CITY OF PORTLAND

This is to certify that MADDEN TIMOTHY L /Scott Pettis
 has permission to Single Family Home/ 40' x 28' Single family home 26' x 10' 339 J 050
50 FARRAGUT ST 339 J 050

ONE AND TWO FAMILY	PLAN REVIEW	CHECKLIST
Soil type/Presumptive Load Value (Table R401.4.1)		
Component	Submitted Plan	Findings/Revisions/Dates
STRUCTURAL		
Footing Dimensions/Depth (Table R403.1 & R403.1(1), (Section R403.1 & R403.1.4.1)	9x18" 4' Deep 8" wall	9/6/05 Tel/con w/ contractor + New plans.

1 FIRST FLOOR FRAMING PLAN
SCALE: 1/4" = 1'-0"

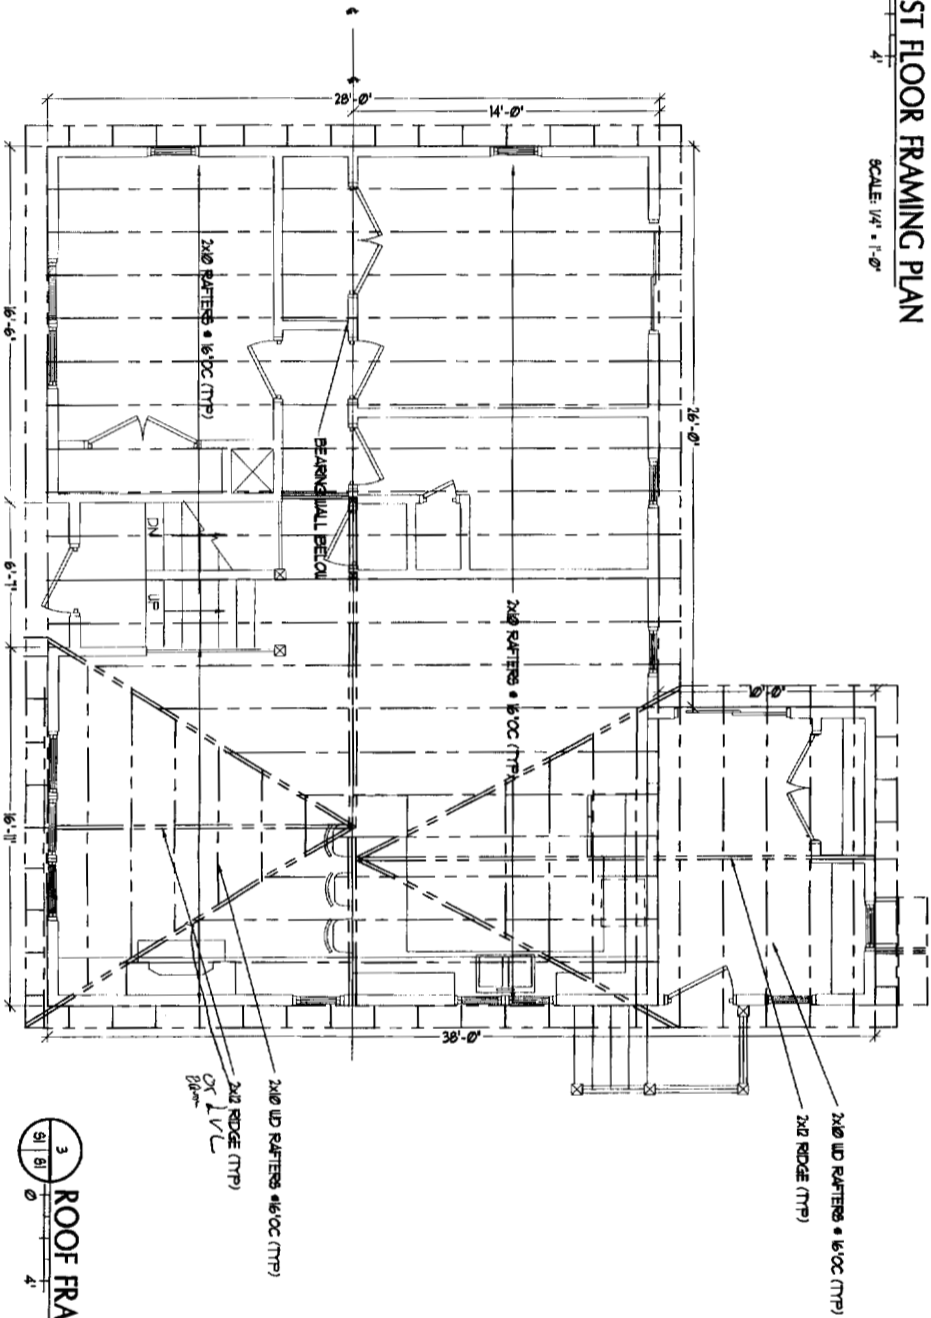
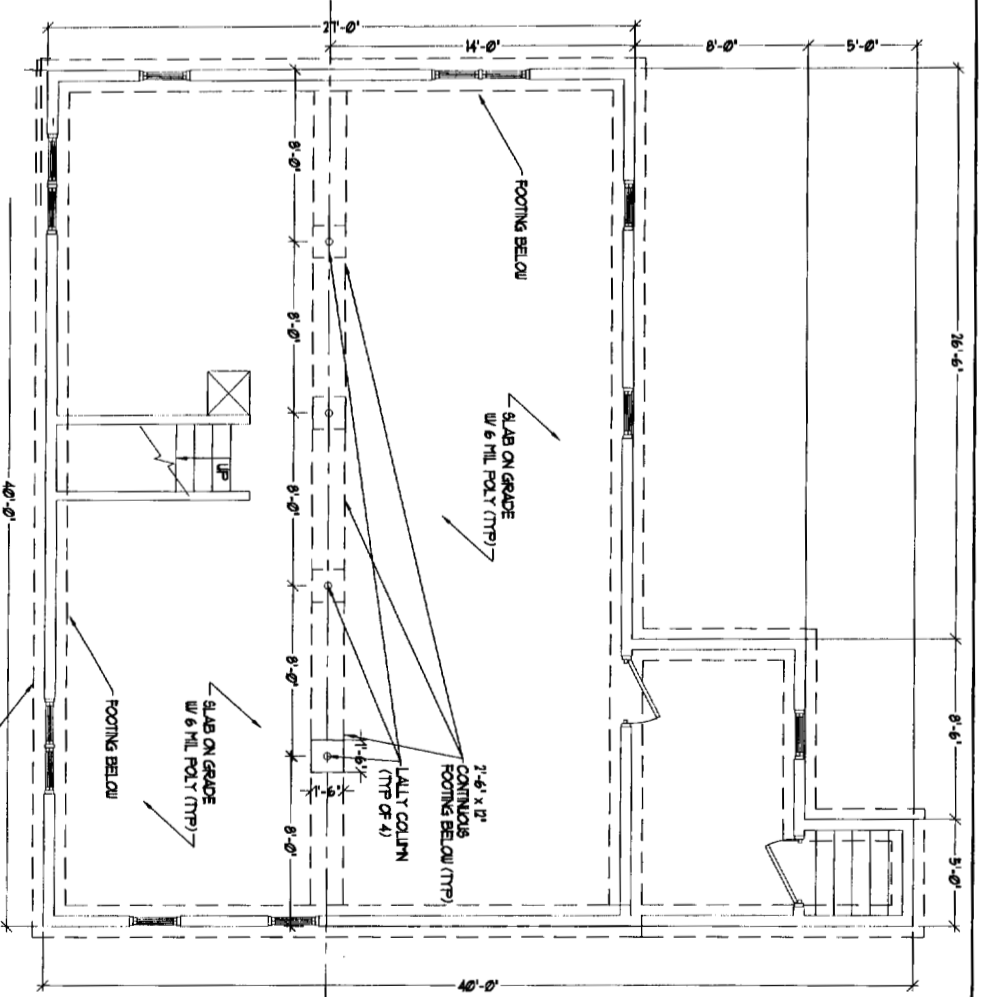
0612912005-ldobson: LM w/ Scott Pettis need more info - Foundation plan, Fully labeled framing, cross sections, deck detail, header schedule, roof framing detail, real construction cost LJD

(2) Anchor Bolts/Straps, spacing (Section R403.1.6)	Size + spacing	OK 1/2" 6' o.c. @ corners
(3) Lally Column Type (Section R407)	3- 2x12's (Bearing wall under?)	1 Floor
Girder & Header Spans (Table R502.5(2))	Span need footing	- can span 8'10" OK
Built-up Wood Center Girder Dimension/Type	" "	
Sill/Band Joist Type & Dimensions	2 x 6 Pi	
First Floor Joist Species Dimensions and Spacing (Table R502.3.1(1) & Table R502.3.1(2))	2x10's - 16" OC	
Second Floor Joist Species Dimensions and Spacing (Table R502.3.1(1) & Table R502.3.1(2))	N/A	
Attic or additional Floor Joist Species Dimensions and Spacing (Table R802.4(1) and	N/A 2x6 16" o.c.	ceiling tie in 3/4 of house

R802.4(2))		
Pitch, Span, Spacing & Dimension (Table R802.5.1(1) - R 802.5.1(8)) Roof Rafter; Framing & Connections (Section R802.3 & R802.3.1)	2x10's w/ LVL	Ridge Beam fasteners both ends of rafters
Sheathing; Floor, Wall and roof (Table R503.2.1.1(1))	3/4" floor / 1/2" wall / 5/8" Roof	
Fastener Schedule (Table R602.3(1) & (2))	IRC 2003	
Private Garage (Section R309) Living Space ? (Above or beside)	N/A	
Fire separation (Section R309.2)		
Opening Protection (Section R309.1)	N/A	
6 Emergency Escape and Rescue Openings (Section R310)	not shown	Updated Plans OK
Roof Covering (Chapter 9)	Asphalt	
5 Safety Glazing (Section R308)	Bedroom - windows within 2' of doors	Removed OK
Attic Access (Section R807)	N/A	Attic Access 22x30 OK
6 Chimney Clearances/Fire Blocking (Chap. 10)	not shown	2" clearance & draftstop OK
7 Header Schedule (Section 502.5(1) & (2))	Not shown - need 2-2x10 in bearing wall	LVL's for ridge condition OK

Shows 2-2x10 Needs 3-2x10 Beam @ 10'-15' width
 max = 8'6"
 36" Guard L 4" space handrails w/ returns
 per contractor 9/6/07
